OUT21/4438

Narrabri Underground Mine groundwater model review

Advice to DPIE Planning & Assessment regarding the groundwater model for the Narrabri Underground Mine and the Stage 3 Extension Project (SSD-10269)

Figure 2.1 Water balance time series January 2009 to June 2019

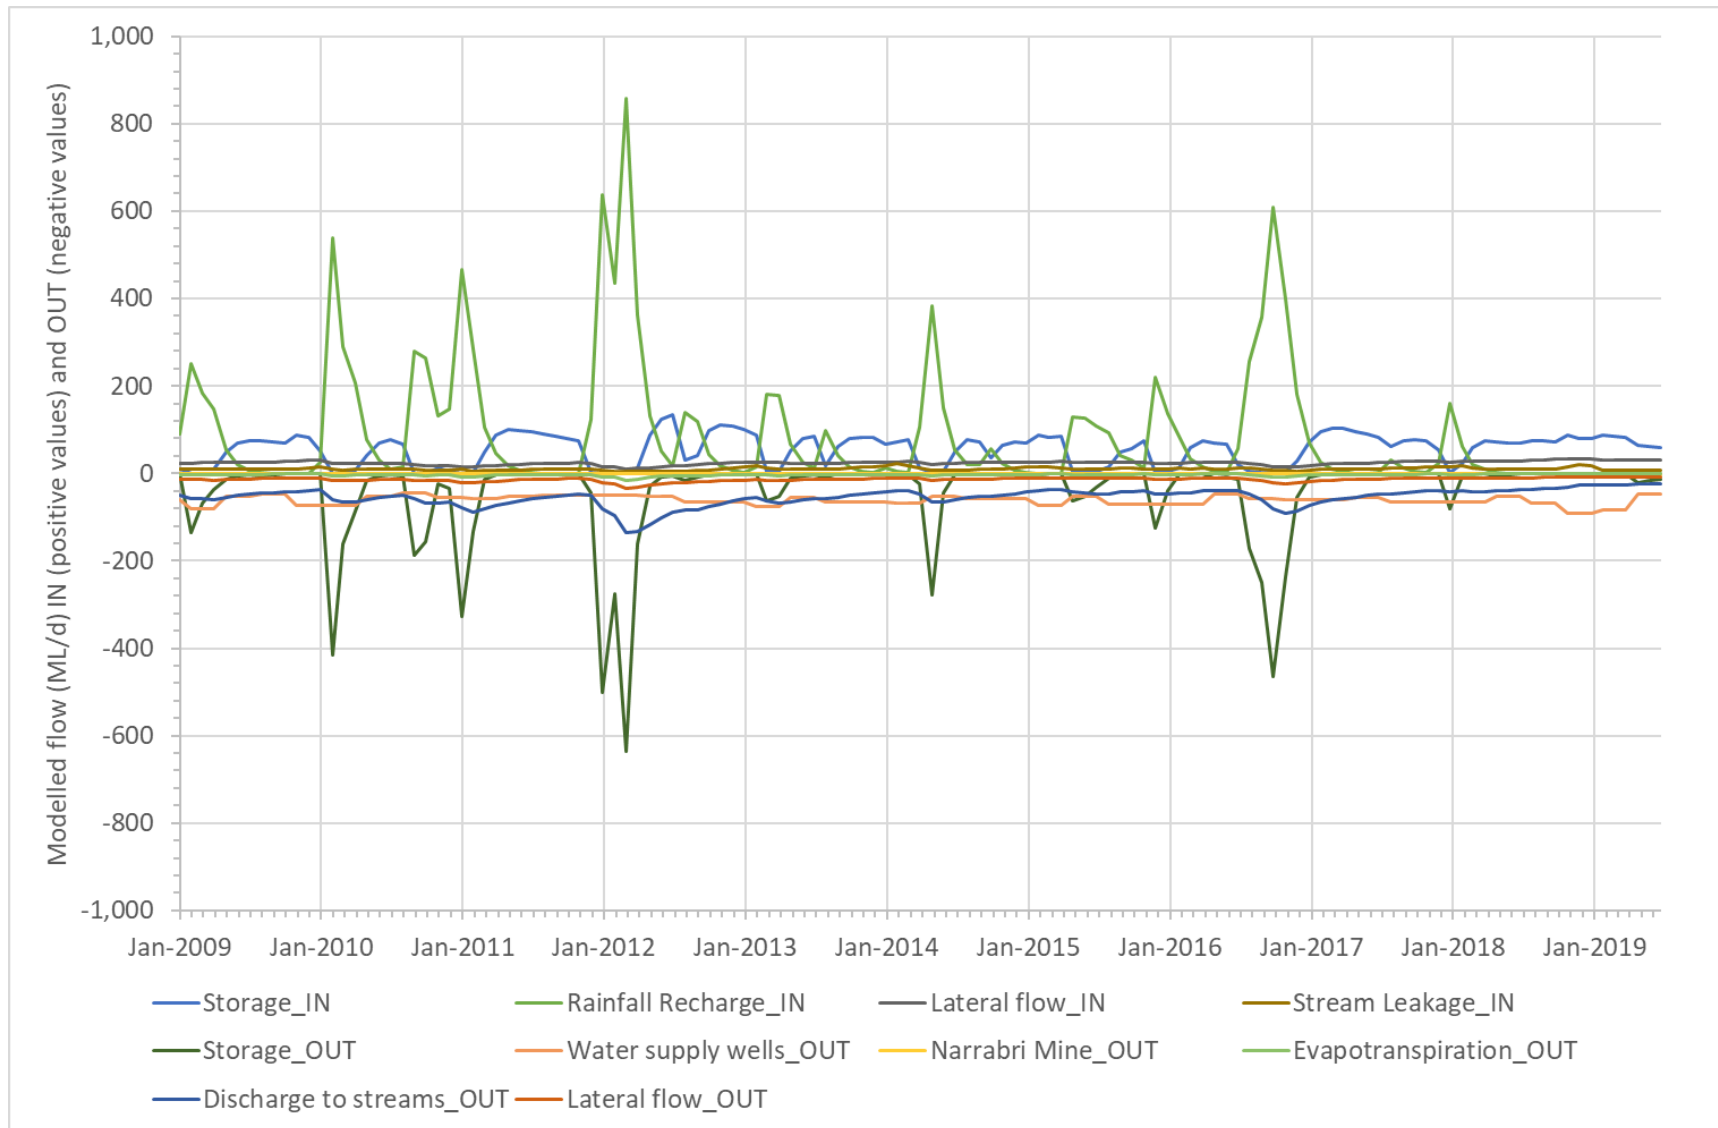
- The water balance needs review. The model appears to suggest that mining will result in increased surface water flows, and increased groundwater (aquifer) storage.

- The water balance appears to say modelling will increase surface water flows and groundwater storage. This is counter intuitive. Surface water gauging suggests that the surface water in the area mainly loses flow to groundwater, some of which may be returned downstream. Ephemeral water is expected to be fed by surface (or near-surface) flow. Representation of ephemeral surface water in the model needs to be reviewed and justified. At the moment it doesn't allow surface water losses into the underlying aquifer.

- h. A review of the initial assumption for the transient model is required. The report indicates a positive value for the change in groundwater system's storage (7.9 ML/day, the equivalent to ~2.9 GL/year or a total increase in groundwater storage of 30.3 GL over the transient modelling period 1 January 2009–30 June 2019). This appears inconsistent with the rainfall conditions during that period.

- i. A review of the assumption resulting in an apparent gain in surface water systems from groundwater. DPIE Water finds the outcome counter-intuitive and suggests field data may indicate the opposite relationship. Evidence needs to be shown to support the current assumptions.
